**M25 junction 10/A3 Wisley interchange
TR010030**

**9.102 Applicant's Response to
Interested Parties Comments on the
ExA's Third Written Questions**

9.102 Applicant's Response to Interested Parties Comments on the ExA's Third Written Questions

Rule Number:	Rule 8(1)(b)(i)
Planning Inspectorate Scheme Reference	TR010030
Application Document Reference	TR010030/9.102
Author:	M25 junction 10/A3 Wisley interchange project team, Highways England and Atkins

- A245 eastbound to the A3 northbound on-slip, as shown on drawing XX-SK-CH-000040 Revision C01, these drawings all within

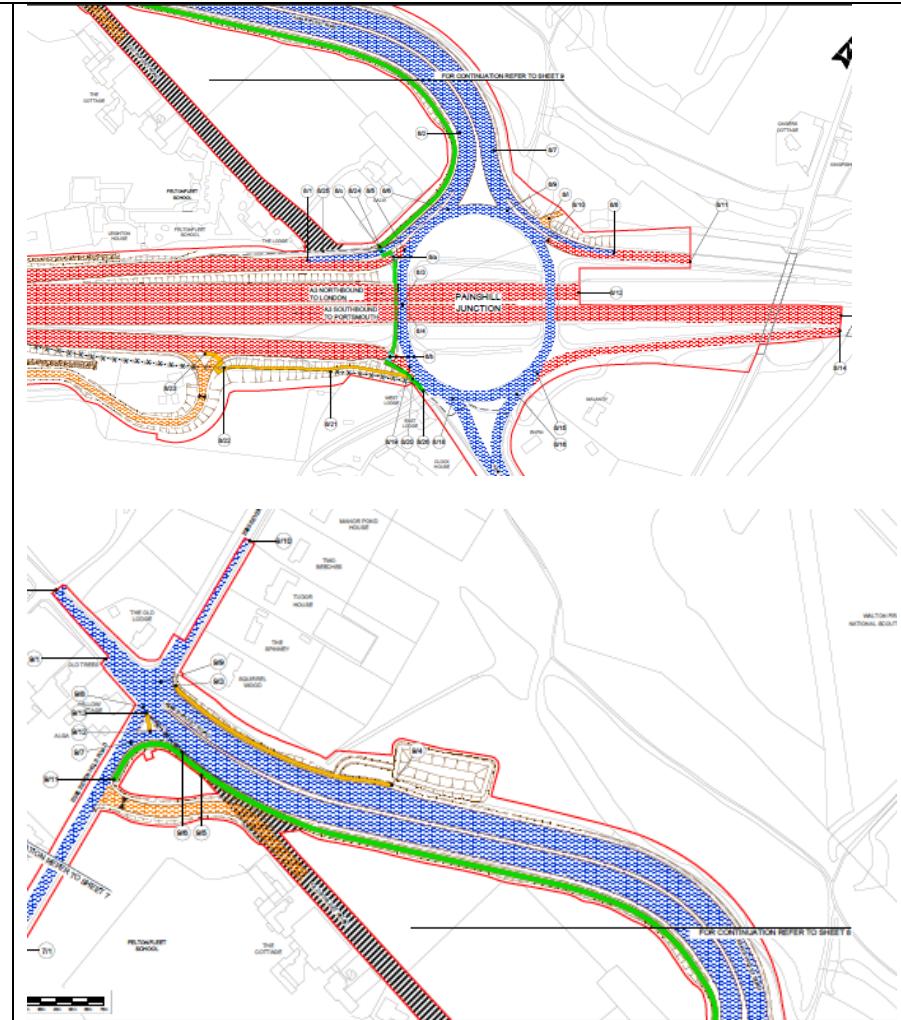
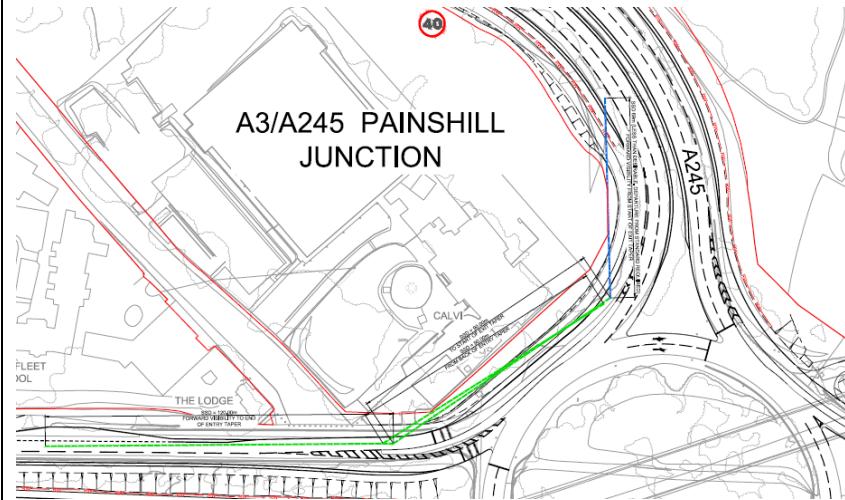
3.13.5	Applicant and SCC	<p>With respect to forward visibility at:</p> <ul style="list-style-type: none"> - the A3 northbound off slip to the A245 westbound, as shown on drawing XX SK-CH-000037 Revision C01; - the new drainage pond access junction with the A245 eastbound, as shown on drawing XX-SK-CH-000039 Revision C01, - A245 eastbound to the A3 northbound on-slip, as shown on drawing XX SK-CH-000040 Revision C01, these drawings all within [REP4- 006]: <p>who is the relevant highway authority with responsibility for determining compliance with appropriate design standards, having regard to the owners and rights shown and declared on the Land Plans and within the BoR [REP5a-005], most particularly in respect of land plots 6/22, 8/31 and 8/36, which suggest that those junctions form or would form part of the strategic highway network rather than the local highway network?</p>	<p>SCC's view is that ultimately the organisation who will be responsible for the road in the future, should be the organisation who should "sign off" the design of the road that they will be responsible for upon completion of the scheme. The A245 forms part of the Local Road Network.</p> <p>The applicants Streets, Rights of Way and Access Plans Regulation 5(2)(k) TR010030/APP/2.4 Sheet 8 and Sheet 9 of 31 show the New or improved highway - side roads in Blue "netted" shading – this being SCC's Local Road Network in this area</p>  <p>So where the M25 junction 10 project will result in changes to roads that SCC is responsible for, it should be the scheme</p>	<p>Whether or not these design features are within the strategic road network or local highway network they will form elements of the authorised works pursuant to the DCO. Therefore, it is for the Secretary of State to approve them as a matter of preliminary design at this stage and in due course to approve the detailed design under the relevant DCO requirement.</p> <p>Insofar as any necessary rights over land are required to construct and or maintain these elements in circumstances where those rights cannot be obtained there are other means by which mitigation can be achieved, such as traffic signal control as an alternative to a visibility splay.</p> <p>Discussions about the detail of these matters continue with SCC as referred to in section 2.4.1 of the Statement of Common Ground.</p>

Question No	Question to:	Question:	Interested Party's Response	Highways England
			<p>promotor/applicant (Highways England), as the designer of the scheme (under the Construction Design and Management Regulations 2015) who should demonstrate to the satisfaction of the future road owner (SCC) as to whether our future road meets design standards and is safe or not, and if not what the mitigation might be. This will allow SCC to decide whether the design is acceptable or not.</p> <p>To date SCC have not seen the Road Safety Audit or achievable visibility splays/forward visibility in many locations and whether they meet design standards or require a departure and associated mitigation.</p> <p>If the land that affects the forward visibility becomes Highways England, or unless they have rights over it to enter it and undertake necessary maintenance, and together with the network itself, becomes part of the SRN, the responsibility lies with LHA (eg SCC) – which is something SCC would not want to take on, as it's not us who's creating the departures.</p> <p>If additional land is required to achieve forward visibility requirements for the local road network then SCC will require to have the title of the land to enter it and undertake necessary maintenance.</p> <p>If there is any vegetation within visibility splays that will require removal and hence ongoing maintenance that would in future fall to SCC then SCC will require the relevant commuted sum payments from the applicant to remove the additional financial burden on SCC.</p> <p>A3 northbound off slip to the A245 westbound, as shown on drawing XX-SK-CH-000037 Revision C01</p> <p>The visibility "lines" shown on drawing XX-SK-CH-000037 Revision C01 are singles lines and not a visibility envelope as vehicles travel from A3 northbound off slip to the A245 and so SCC believe that to achieve the visibility splay shown will impact upon land outside of the highway boundary and mature trees in both highway ownership and possibly outside.</p>

Question No	Question to:	Question:	Interested Party's Response	Highways England
			 <p>The applicant/Highways England are showing this area of land (plot 6/22 and other plots around the A3-A245 boundary) as title acquisition in this area and but is shown in the Book of Reference as Highways England already owning title.</p> <p>The key issue at this location is that when considering the visibility envelope it would be the owner of the land required for the forward visibility for the two slips that's needed to be included within the DCO red line boundary but is not.</p> <p>From consideration of the Book of Reference Plot 6/22 and other plots around the A3-A245 boundary e.g. plot 8/10, 8/11, 8/14, 8/16 are within Highways England ownership. But other plots are not e.g. 8/15 SE power networks, 8/37, 8/37a Feltonfleet school and there are plots outside of the red line boundary affected by the required visibility envelope that look to be outside of the highway boundary e.g. owned by Felton Fleet school in the case of the off slip (westbound into A245)</p> <p>New drainage pond access junction with the A245 eastbound , as shown on drawing XX-SK-CH-000039 Revision C01,</p> <p>Considering the new drainage pond access junction with the A245 eastbound, the forward visibility as shown on drawing XX-SK-CH-000039 Revision C01 would appear to be acceptable and it is believed can all be contained within highway, given its location on the outside of the bend.</p> <p>Visibility splays for vehicles existing the junction should be shown however so that vehicles exiting the drainage pond access can see any queuing vehicles queuing back form the Painshill junction along the A245 and are not obscured by buses waiting at the bus stop. This may impact upon plot 8/39 which again is shown as title acquisition in this area and referring to the Book of Reference is currently owned by Burhill Developments and so not currently under highway ownership. There may also appear to be an impact on plot</p>

New drainage pond access junction with the A245 eastbound , as shown on drawing XX-SK-CH-000039 Revision C01,

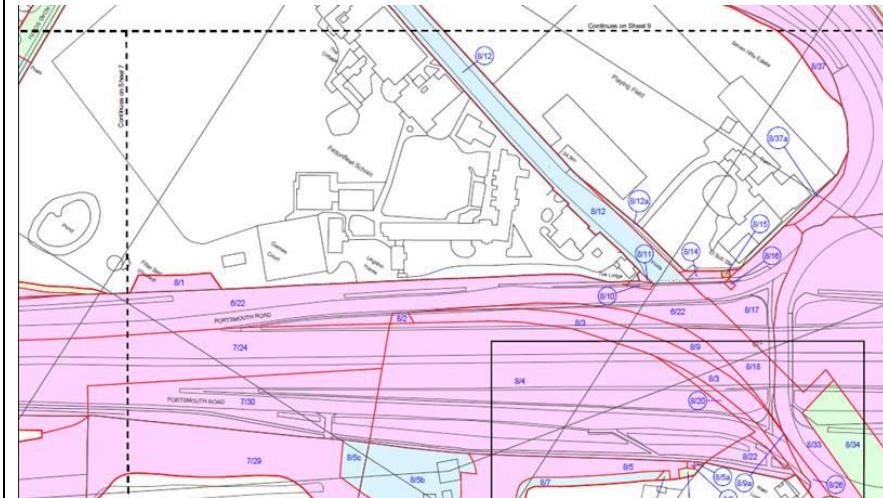
Question No	Question to:	Question:	Interested Party's Response	Highways England
			<p>9/13 which is shown in the Book of Reference as owned by Felton Fleet school. SCC would ask for clarity from the Applicant regarding these areas.</p> <p>SCC requested the Road Safety Audit in this location and previously raised this with the applicant, (see SCC's response dated 7th May 2019 to Pre-Application Consultation – Additional Non-Statutory Targeted Consultation). The access is “square onto the A245 and so would require a vehicle to perhaps stop on the A245 to make the turn. SCC's response at that time was as follows:</p> <p>“SCC note that an access road to the pond is shown but would ask has this arrangement had a Road Safety Audit (RSA) and if so a copy of this RSA could be provided to SCC, with the relevant section of the RSA indicated, to show how vehicles can safely access this pond from the A245 to avoid such risks as rear shunts? Also is the access road to be gated and if so would the location of this gate allow safe access/egress and avoid such issues as fly tipping?”</p> <p>The applicant (Highways England) submitted a Road Safety Audit late on the 9th April 2020 (Document Ref: HE551522-ATK-GEN-XX-RP-CH-000009). This road safety audit only covers two issues (both related to the Pond access junction with A245, east of junction with Seven Hills Road). The two actions are:</p> <ul style="list-style-type: none"> - A formal access junction or vehicle crossover can and will be provided during detailed design stage. The addition of formal access junction or vehicle crossover will reduce the risks of conflicts and collisions – SCC accepts that addressing this in the detailed design is possible - A turning facility can and will be provided during the detailed design stage. The provision of a turning facility within the pond area will eliminate the risks of collisions involving reversing vehicles - it is not clear to SCC whether this turning facility can be provided within the red line boundary and so SCC ask that this be clarified

A245 eastbound to the A3 northbound on-slip, as shown on drawing XX- SK-CH-000040 Revision C01

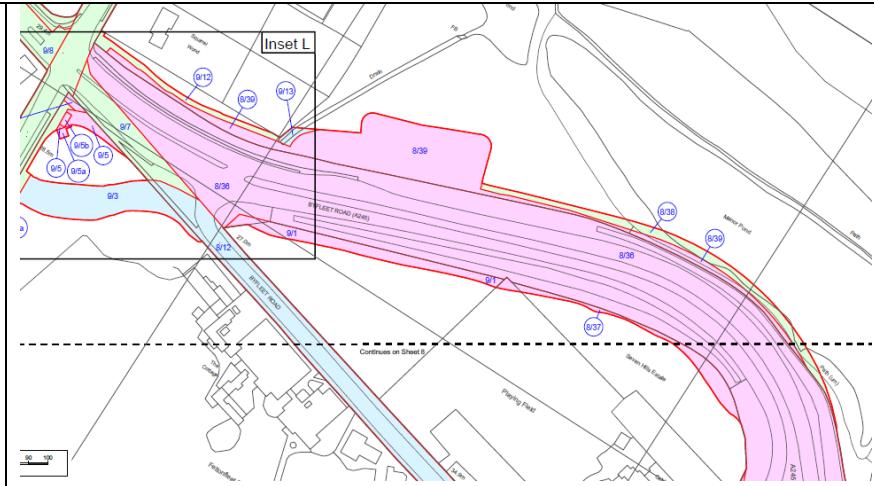
Question No	Question to:	Question:	Interested Party's Response	Highways England
			 <p>A245 eastbound to the A3 northbound on-slip, as shown on drawing XX- SK-CH-000040 Revision C01. Considering the A245 eastbound to A3 northbound on-slip again the visibility "lines" shown on drawing XX-SK-CH-000040 Revision C01 are singles lines and not a visibility envelope as vehicles travel from A245 eastbound to the A3 northbound on slip to the A245 and so SCC's view is that this visibility envelope should be plotted to demonstrate that the visibility requirements will not impact upon land outside of the highway boundary?. This impacts on plot 8/31 which again is shown as title acquisition in this area but referring to the Book of Reference is within Highways England ownership. There may be issues and potentially with plots 8/38, 8/39 owned by Burhill Developments and so not in highway ownership and 8/32 is within Highways England ownership which may need clarification.</p>

Figure 3-1 Layout of south-facing slips at Ockham as proposed by RHS

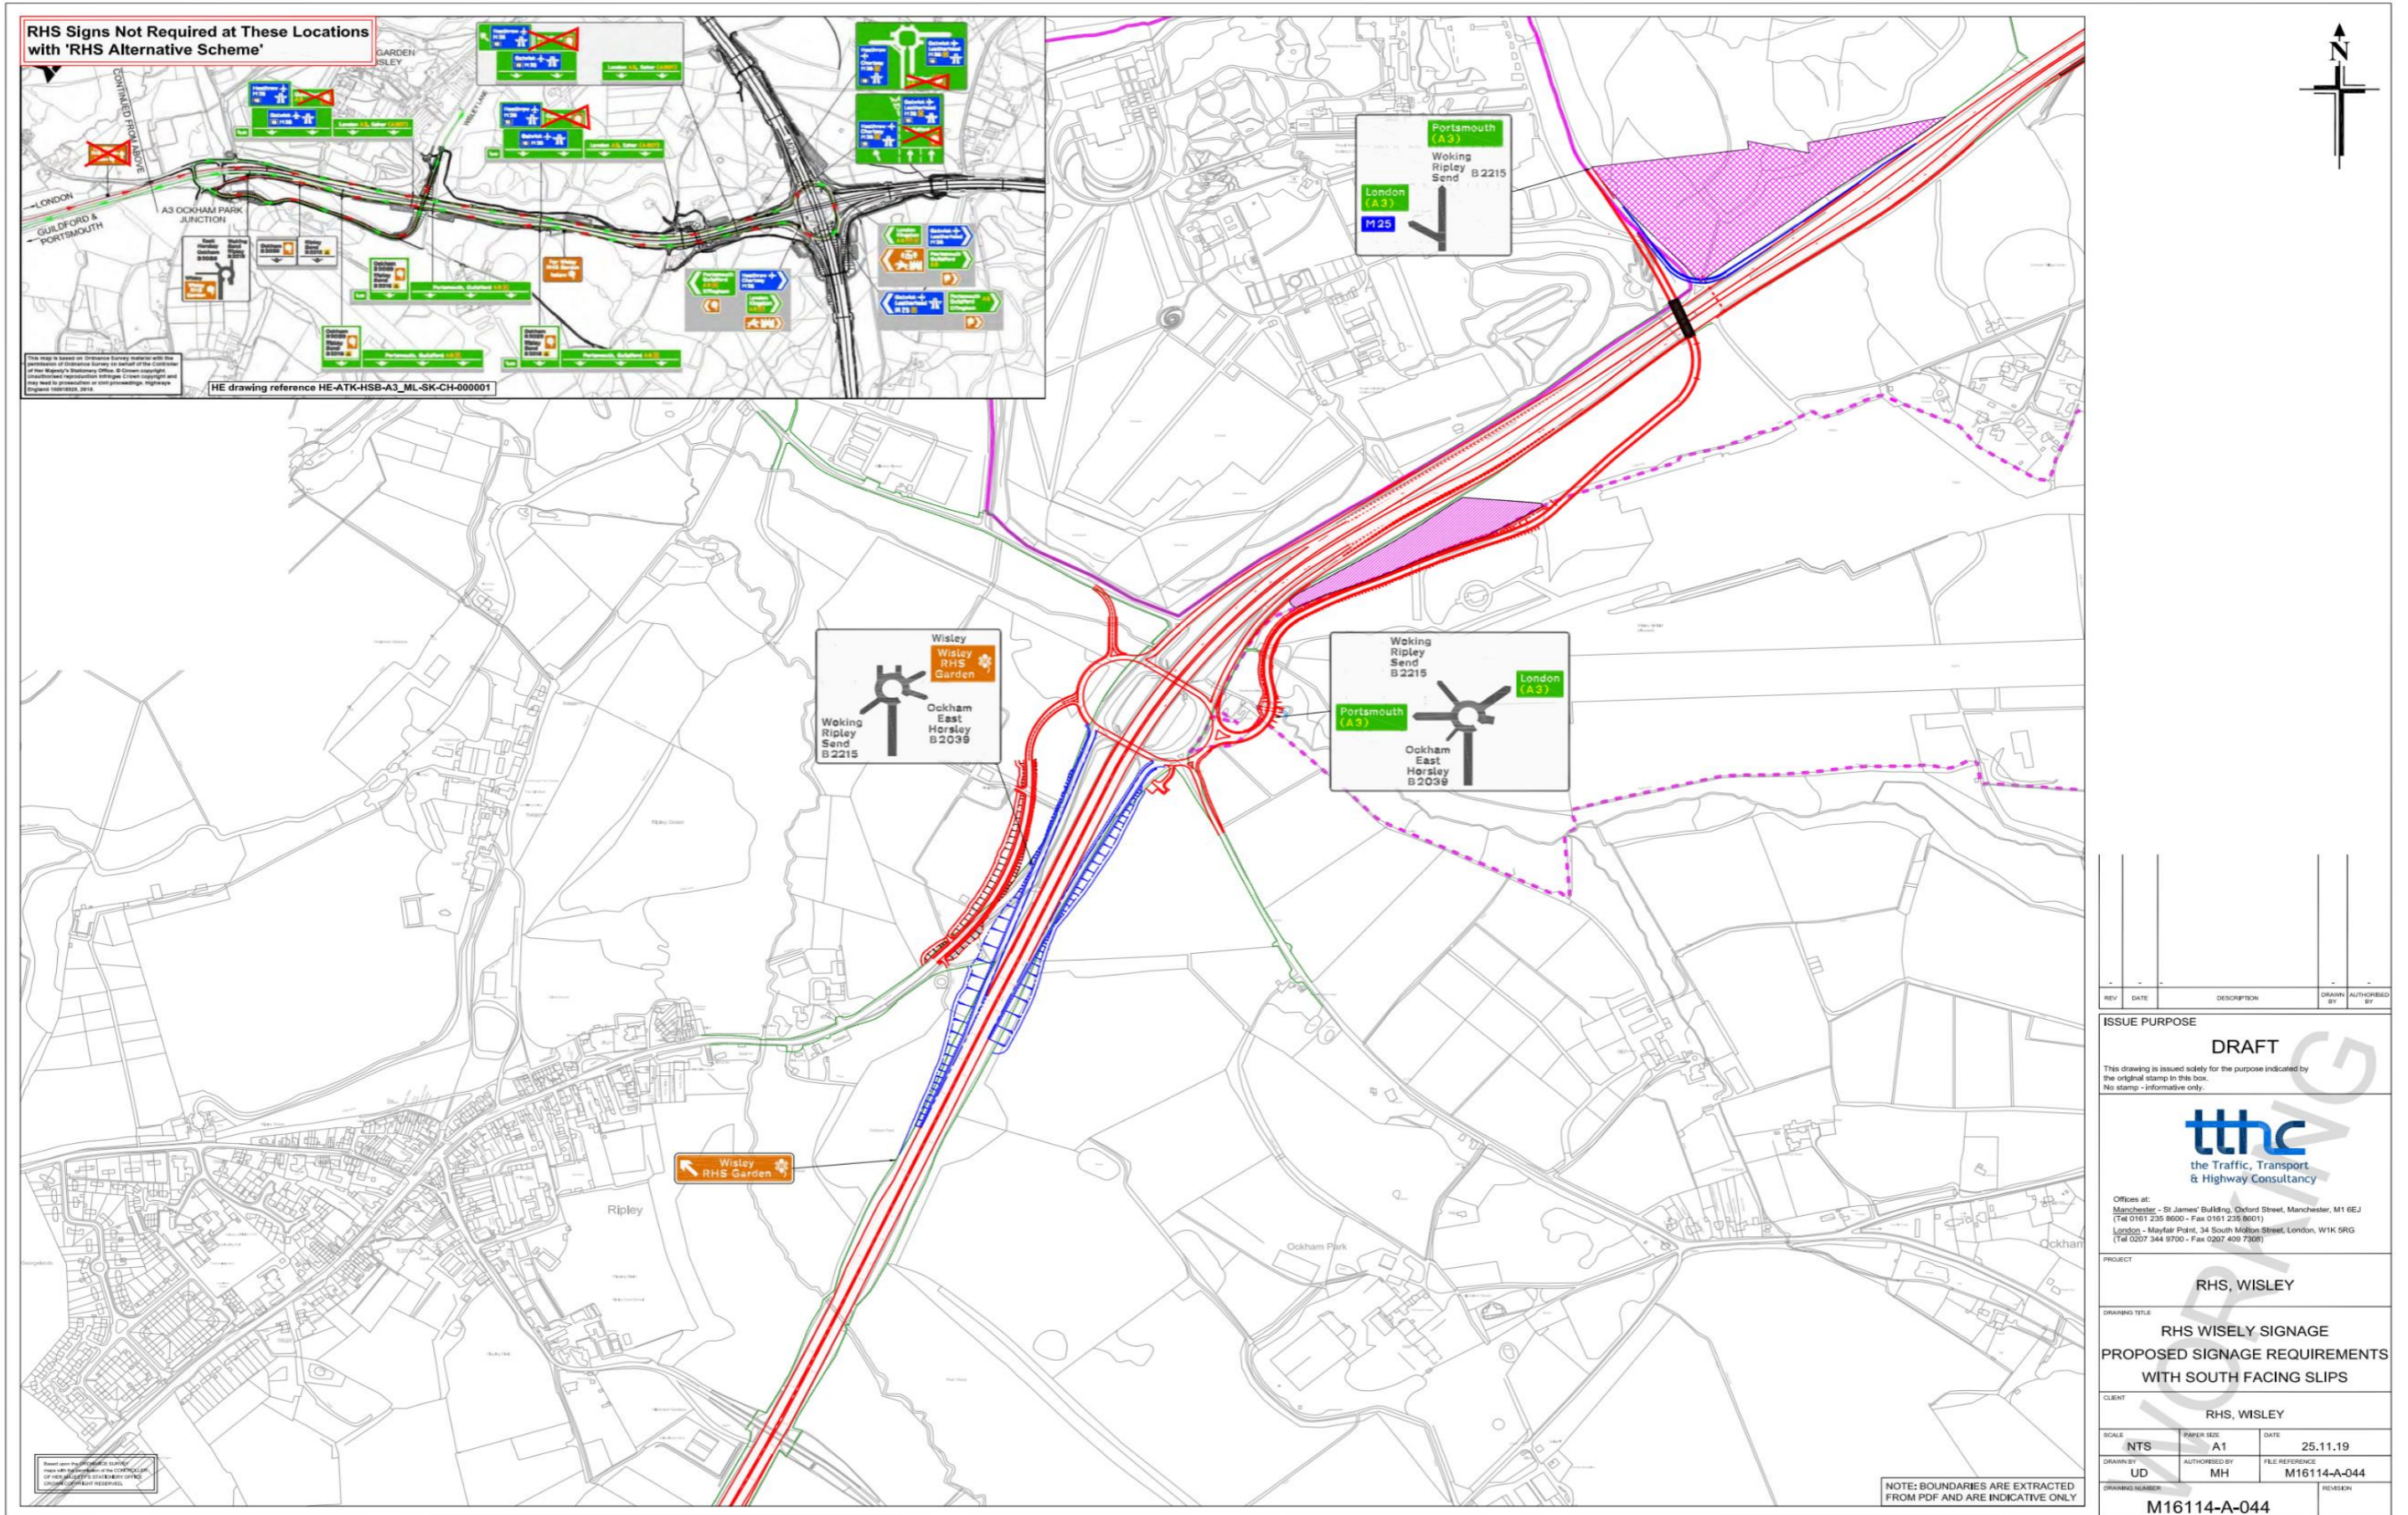
13	Traffic, Transport and Road Safety			
3.13.2	Applicant and SCC	<p>While the ExA is aware that the Proposed Development does not and will not include south facing slips at the Ockham Park Junction, the ExA considers that in order for it to understand what the hypothetical effect the availability of south facing slips would have on the predicted distribution of traffic on the strategic and local road networks within the vicinity of Ripley, that the Applicant and/or SCC should extend the traffic modelling that has already been undertaken to date to include model runs that incorporate south facing slips at the Ockham Park junction.</p> <p>In this regard the ExA considers a collaborative approach is necessary and that it is for the</p>	<p>It has been agreed with HE that the Applicant will undertake the traffic modelling of south-facing slips at Ockham Park junction.</p> <p>SCC understand that full reporting of the results of this traffic modelling will be provided at Deadline 8, since there is insufficient time to complete the modelling and fully report on the results by Deadline 7. Nonetheless, the following initial conclusions have been made by HE from the spreadsheet modelling undertaken to date, the assumptions made and the currently available outputs have been set out as follows:</p> <ol style="list-style-type: none"> 1. All Wisley Lane traffic, including RHS traffic, to and from the A3 south would utilise the south-facing slips instead of routing through Ripley on the B2215. 2. All Wisley Airfield development generated traffic arriving from the A3 south in 2037 would utilise the south-facing off-slip (northbound) to access the proposed development via Ockham Park junction, rather than route through Ripley on the B2215. 3. All Wisley Airfield development generated traffic heading for the A3 south in 2037 would utilise the south-facing on slip (southbound) via Ockham Park junction when leaving the development site, rather than use Old Lane as indicated by the 2037 DCO Scheme Do-something traffic modelling. 4. Traffic flows along the B2215 through Ripley with the DCO Scheme plus south-facing slips at Ockham Park junction 	See response adjacent to the points being raised below

Question No	Question to:	Question:	Interested Party's Response	Highways England
		<p>Applicant and SCC to decide between themselves which organisation is best placed to undertake the modelling that the ExA is requiring to be undertaken. Should the Applicant and SCC be unable to agree which organisation should take the lead on which one undertakes this modelling then it will be for both the Applicant and SCC to undertake this modelling.</p>	<p>would be effectively unchanged compared to the Do minimum scenarios.</p> <p>5. With the DCO Scheme plus south-facing slips there is a significant reduction in the forecast increase in traffic on Old Lane between the Wisley Airfield site access and the A3 as a result of the rerouting of Wisley Airfield generated traffic heading for the A3 southbound via Old Lane to instead utilising the south-facing on-slip (southbound) via Ockham Park junction.</p> <p>6. It is not known what the impact of the slips might be on other movements that presently or in the future would travel through villages such as Ockham, Effingham, East and West Horsley and Pyrford.</p> <p>7. With the DCO scheme and south facing slips at Ockham Park interchange it is forecast that in 2022 up to approximately 900 vehicles per day would use the off-slip and 700 vehicles per day would use the on-slip road , with less than 85 vehicles per hour using each slip road in any peak hour.</p> <p>8. With the DCO scheme and south facing slips at Ockham Park interchange it is forecast that in 2037 this increases to approximately 2,750 vehicles per day utilising both the off and on slip roads, mostly due to traffic generated by the Wisley Airfield development, with between 150 and 350 vehicles per hour using each slip road in any peak hour.</p> <p>However, SCC do have some further questions and comments on the above, as follows:</p> <p>1. It is unclear what modelling HE are referring to when they state that 'Final reporting of the results of this traffic modelling will be provided at Deadline 8': is it the spreadsheet model or modelling using HE's strategic model? SCC assume the outputs available are based on the former, but it is suggested this is clarified. However, if the full reporting is to be based on other modelling then this should be explained as the outputs will change.</p> <p>2. The outputs are reported are very much based on the assumptions made. For example, output (3) states that all Wisley Airfield traffic heading for the A3 south would utilise the A3 s/b on-slip as opposed to using Old Lane. However, in reality, it is likely to be only a proportion of these trips, albeit potentially the majority that would utilise the new on-slip as other trips might still find the use of the Old Lane junction to access the s/b A3 more convenient depending upon their origin within the development. Consequently, it is the assumptions made driving the outputs rather than the modelling: the spreadsheet model is more a means of displaying these assumptions and the resulting change in</p>	<p>1) As stated by SCC, their responses refer to a spreadsheet model developed by Highways England and shared with SCC to enable this answer to be drafted in time. In the event, answers were available from the strategic traffic model and these were presented as Highways England's response to this question.</p> <p>2) See point 1 above. The comments made by SCC here refer to the spreadsheet model and not outputs from the strategic highway model.</p>
